**KIRKLEES COUNCIL
TOWN AND COUNTRY PLANNING ACT 1990
HIGHWAYS DEVELOPMENT MANAGEMENT**

PLANNING REF 2016/60/94117/E0/SH
CATEGORY Small Major

PROPOSAL OUTLINE APPLICATION FOR
RESIDENTIAL DEVELOPMENT

LOCATION LAND OFF LEES HALL ROAD
DEWSBURY

CM
P0-MP-SPA-IL-P3565-0001-00
PR-ILLUSTRIVE_MASTERPLAN_POL

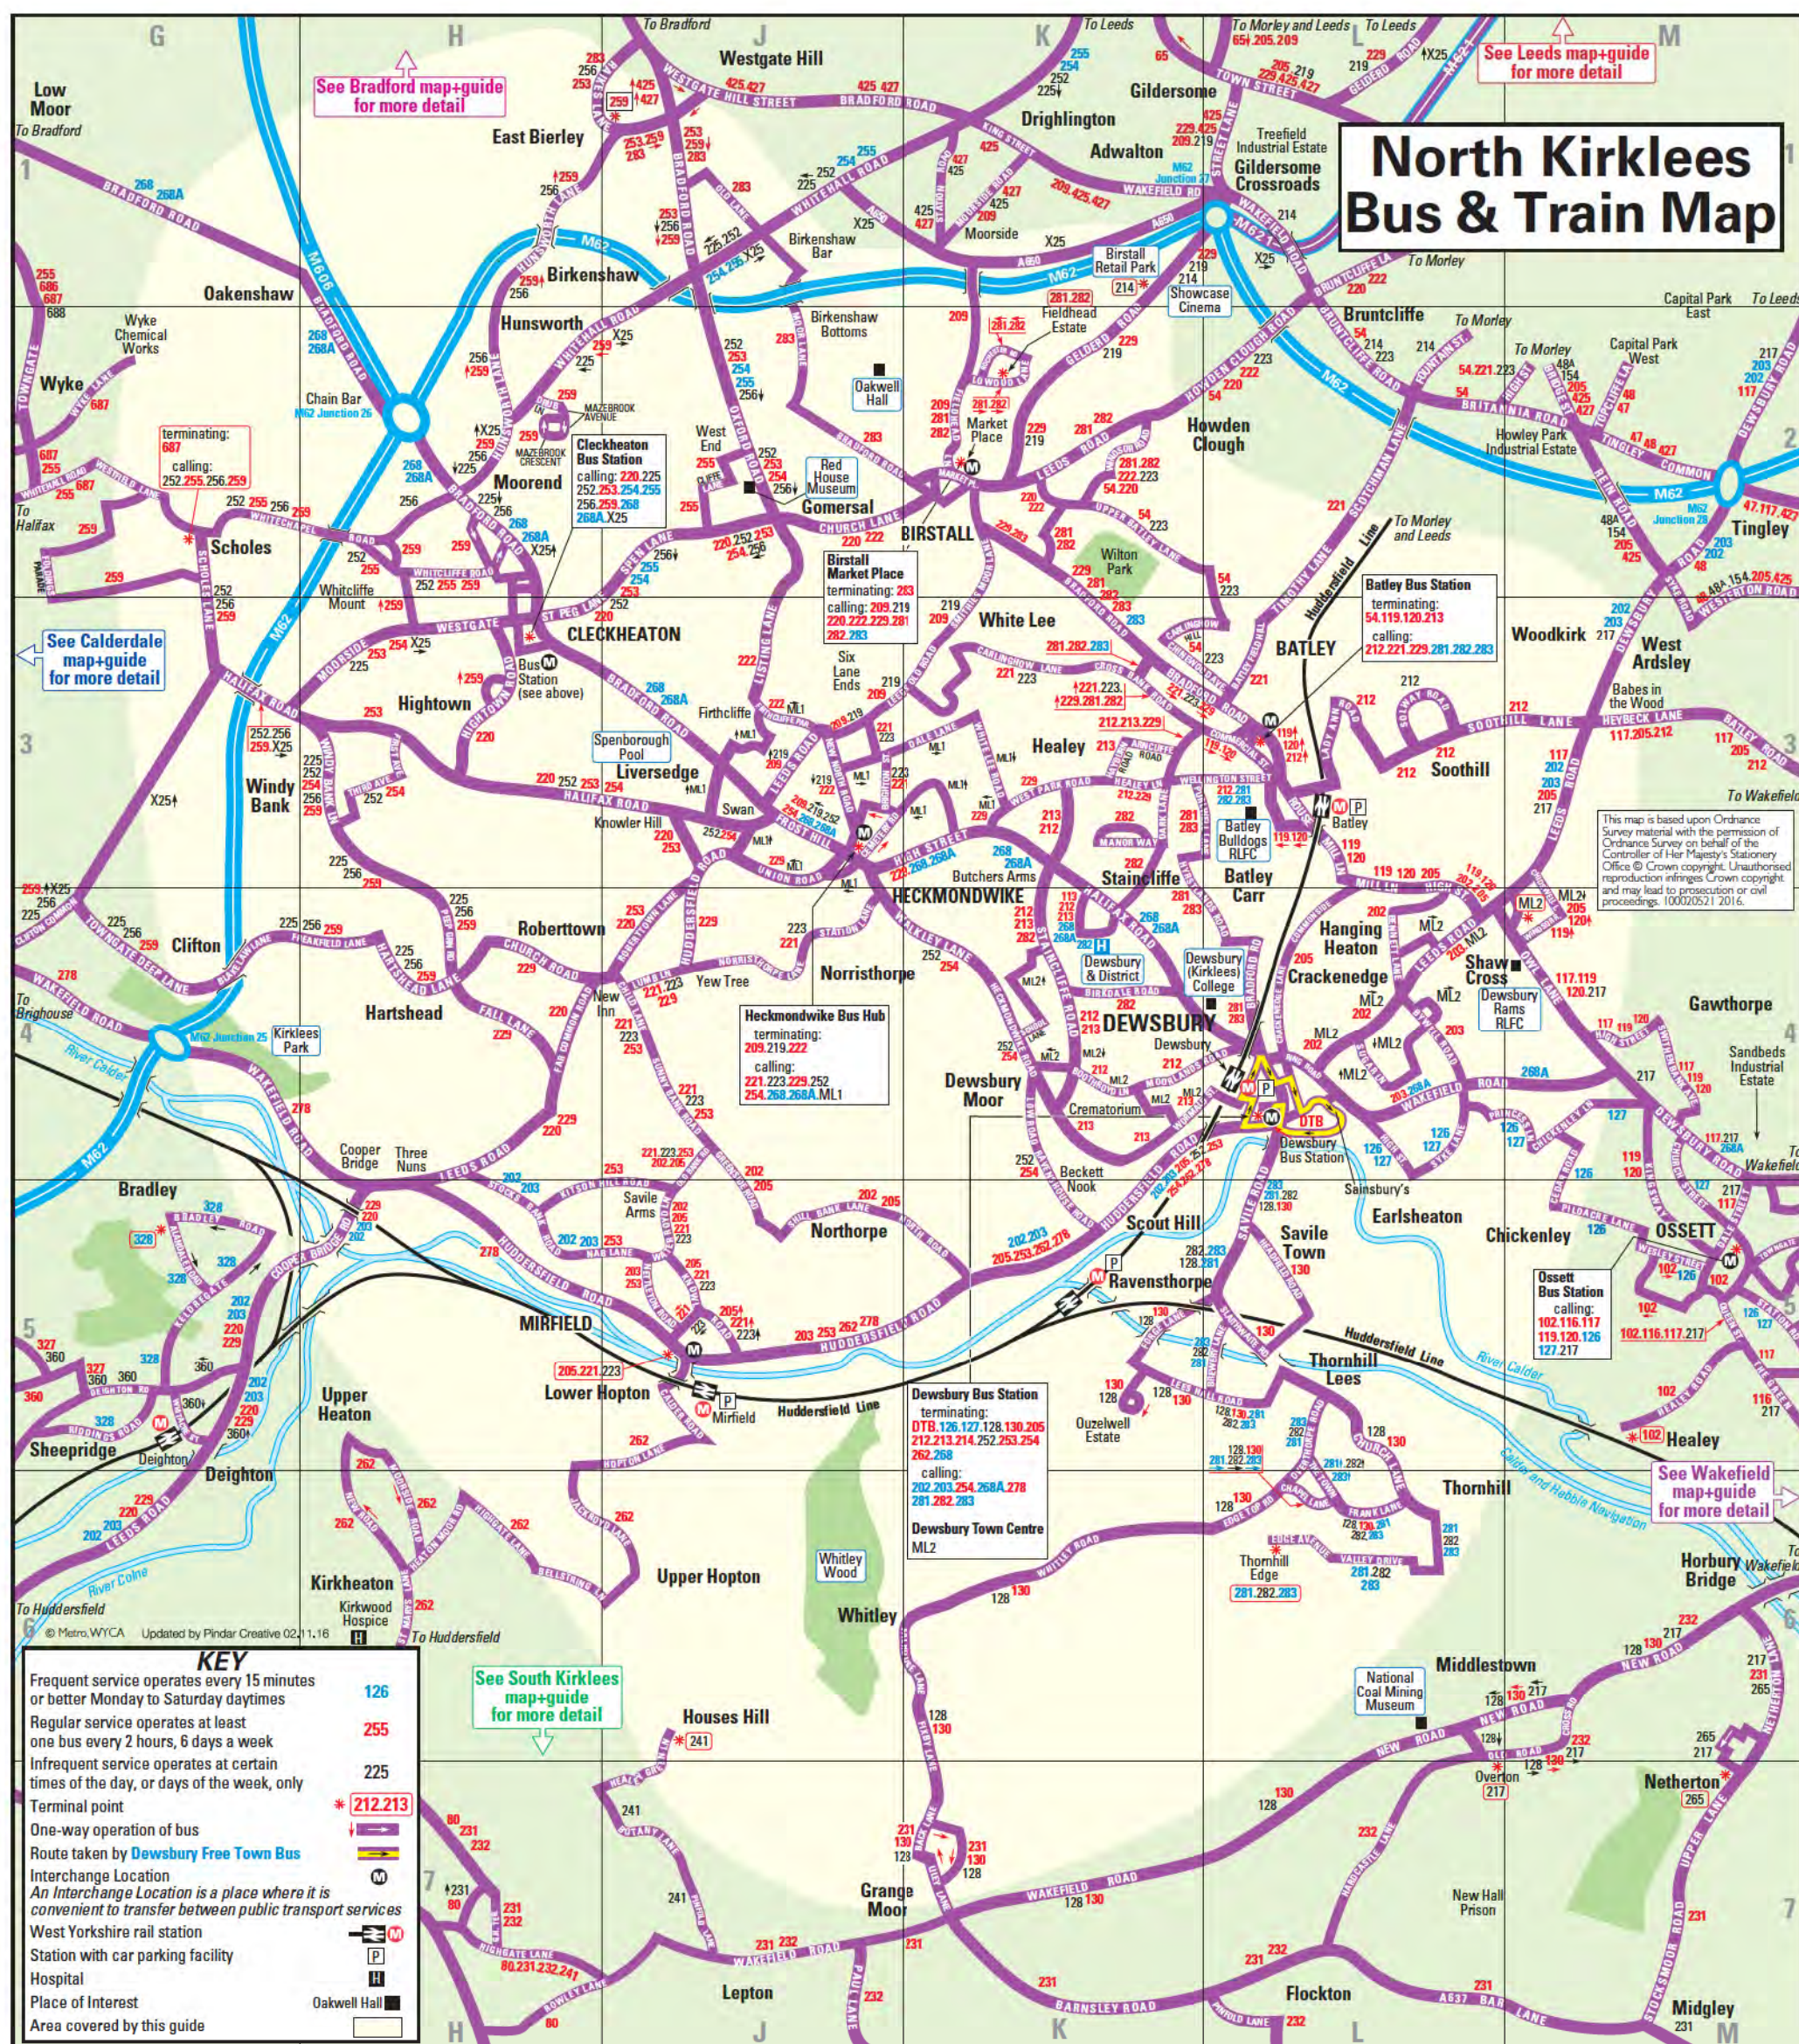
The submitted Transport Assessment provides a study of existing pedestrian infrastructure within the vicinity of the site. There are no pedestrian crossing facilities shown on the Masterplan drawing and clarification from the applicant is requested in this regard.

From the submitted information, it is not entirely clear which areas would be offered for adoption and which would remain private. This will need to be addressed early in the design of any reserved matters application coming forward. Based upon the illustrative masterplan, there are likely to be issues with forward visibility within the adoptable highway.

There is no transition or delineation feature between the traditional estate road and the shared surface area. Where ramps are placed to demarcate different surfaces, the footways should continue beyond the ramp to provide for level pedestrian crossing of the carriageway. Where ramps or other traffic calming features are proposed, they should be positioned to avoid creating or exacerbating captive low points.

There currently don't appear to be any publicly accessible visitor parking spaces provided within the shared surface areas of the development.

Some form of turning facility will need to be provided at all cul-de-sac locations within the site. Vehicles will be required to be able to both enter and exit carways, accessways etc in a forward gear. In addition vehicles should not be required to reverse past the house being visited (except to reverse into the plot driveway) in order to do so.

The turning heads as shown may not be sufficient to accommodate the turning envelope required by Kirklees Council refuse vehicles. Swept Path Analysis Vehicular tracking would need to be provided to demonstrate that refuse vehicles can enter and manoeuvre within the access roads in a safe and efficient manner. Kirklees Council would not expect refuse (or other service) vehicles to enter private roads or forecourts. However it is not clear where the refuse bins or bin collection points would be located. This is a particular concern for those plots not adjacent to the public highway. Bin pads and collection points will need to be located in accordance with Kirklees Council's "Good Practice Guide for Developers" document.

There are no drainage details shown on the site plan drawing. A suitable storm water outfall will need to be identified for the development and has this will require early discussion with Kirklees Drainage Engineers in any reserved matters application coming forward.

Any trees should be positioned outside of carriageway areas. Those positioned within the highway limits should be selected and positioned to avoid forward visibility issues and sightline issues at junctions. The proposed trees within plot frontages should be repositioned so that the ultimate spread of the trees will not overhang the public highway areas.

There is no level information provided with the submission however there are changes in gradients across the site. It is not clear whether retaining walls will be necessary as part of the development. Any retaining structures affecting the highway will require formal technical approval by the Council as the Highway Authority. It is recommended to provide details of all proposed retaining features and underground storage facilities (including pipes) to Kirklees's Highways Structures section at an early stage with any reserved matters application coming forward.
